HAYES STRUCTURAL

Date: February 12, 2025

Re: 25-FRM-026
Framing Inspection
Lot 57 Tobacco Road
59 Grading Stick Court
Angier, NC 27501
Permit No.: SFD2412-0008

At your request, a site visit was made to the above referenced single family residence under construction to inspect two framing concerns noted by the inspector.

**B**  
5.01 BUILDING SECTION THRU GARAGE  
1/8" = 1'-0"

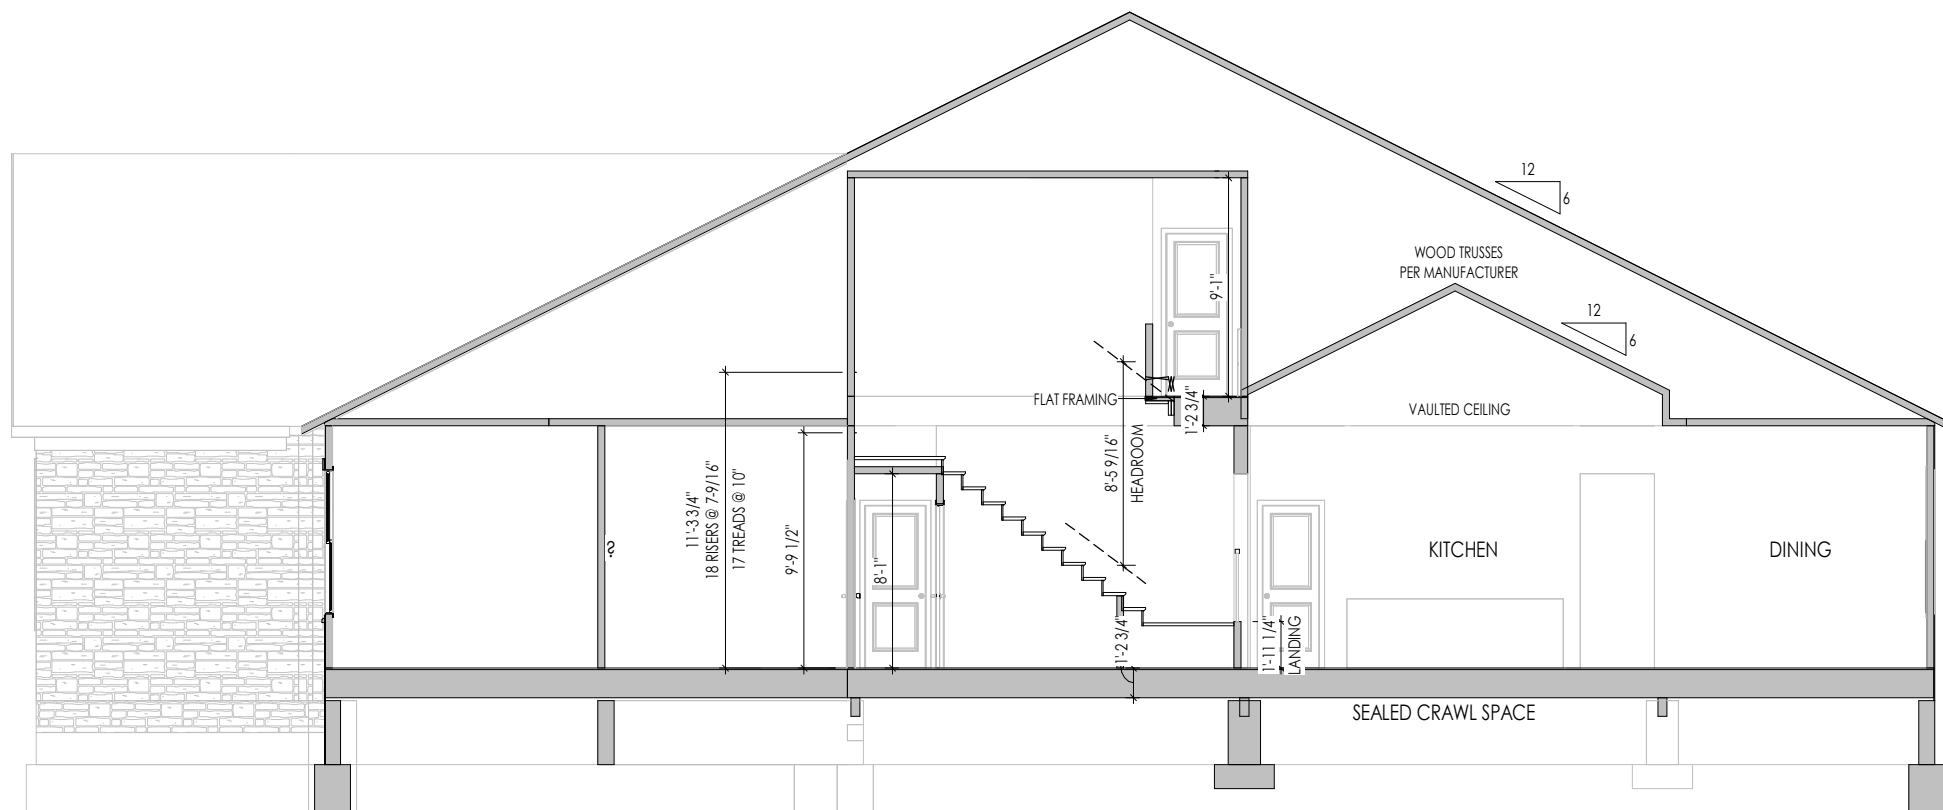
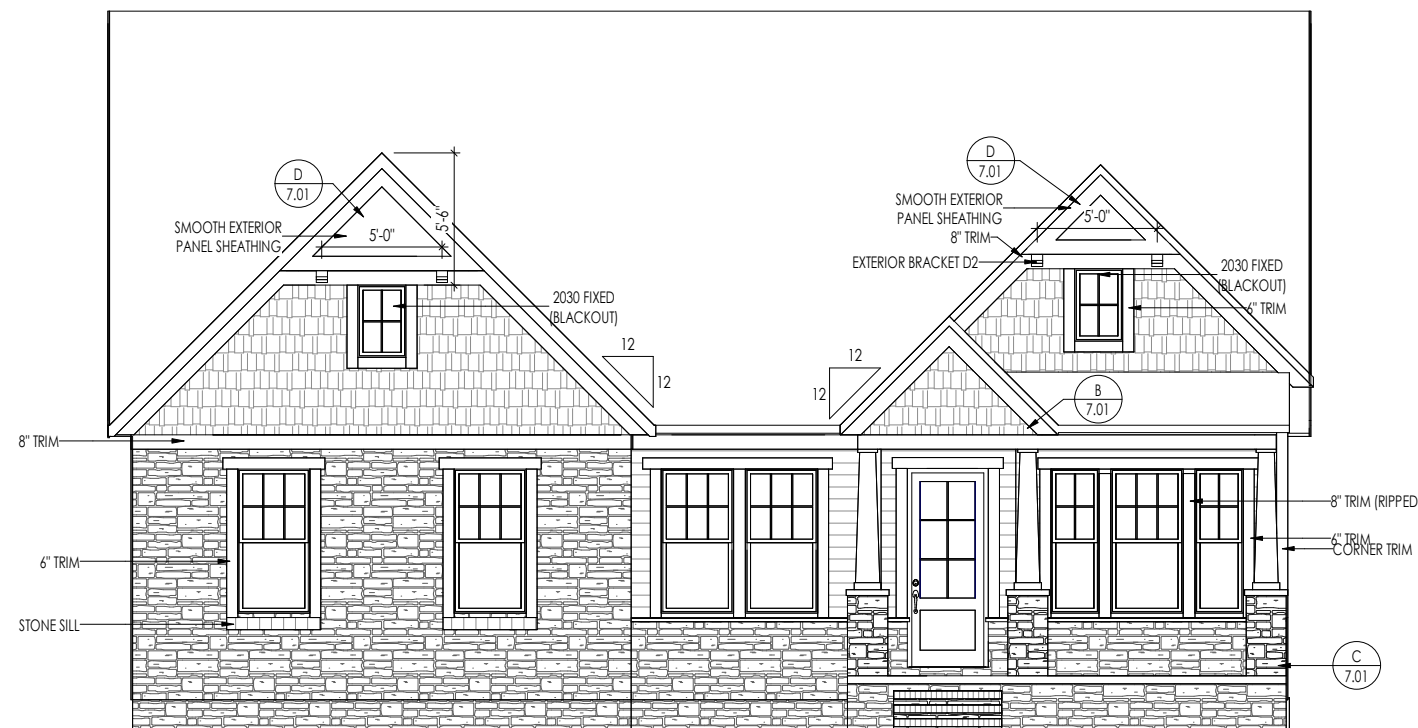
1. The 2x4 @ 16" o.c. pony walls above the garage door headers were measured to be +/- 7'-2" in height, exceeding the maximum allowable height for portal framing. The roof trusses above the front side of the garage span left to right to bear on the pony wall above the one-car garage door header. The roof trusses above the rear side of the garage span front to back, parallel to the pony wall above the two-car garage door header.
2. The cap on the 6x6 post at the right rear corner of the rear porch was not installed properly.

1. Sheath the inside of the left garage wall with 7/16" OSB attached with 8d nails spaced 6" o.c. along panel edges and 12" o.c. in the panel field. Install sheathing in continuous panels extending from the bottom of the headers to the tops of the pony walls. Tie each roof truss to the top of the pony wall above the one-car garage door header with a Simpson Strong-Tie H2.5A hurricane tie unless noted otherwise by the truss drawings. Brace the top of the pony wall above the two-car garage door header with 2x4x8'-0" ties spaced 4'-0" o.c. installed on top of the truss bottom chords extending inwards from the gable truss. Attach the ties to each intersecting bottom chord below with (2) 10d nails.
2. Tie each beam to the 6x6 corner post with a Simpson Strong-Tie H2.5A hurricane tie. The existing damaged post cap may remain in place.
